STAFF REPORT

RE: FINAL PLAT/Beltway Office Park,
Lot 4R

REQUEST: Approval of a final plat

FINAL PLAT
OF
VICTORIA STATION
LOT 1R

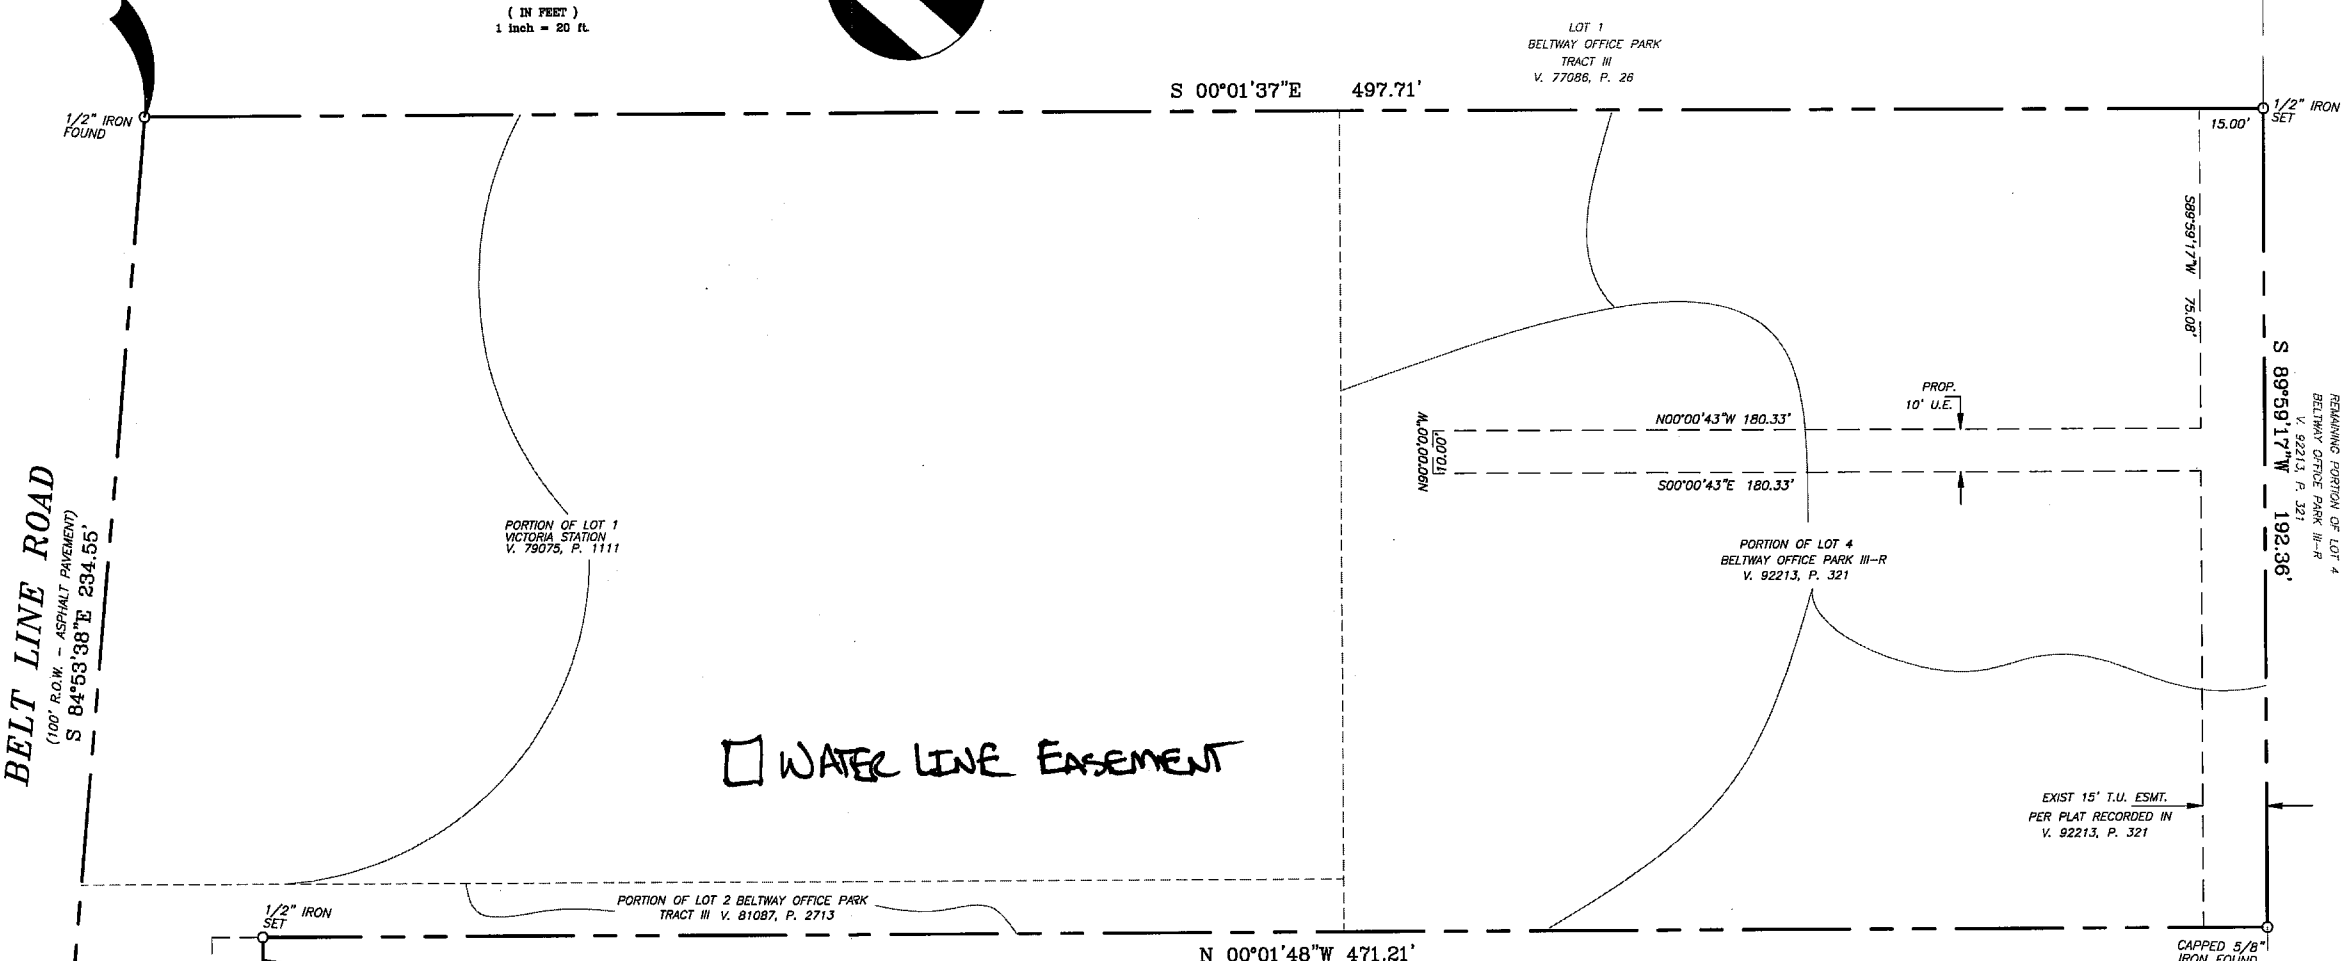
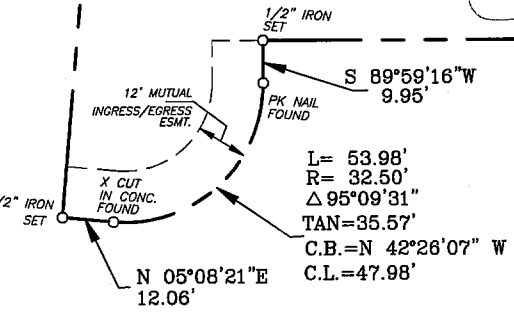
1. The legal description needs to be revised to an owner's certificate.
2. In the legal description, the page reference for Victoria Station Addition does not match the face of the plat and the title block. Please verify.
3. A reference to Lot 2, Beltway Office Park, Tract III, V. 81087, P. 2713 needs to be added to the legal description.
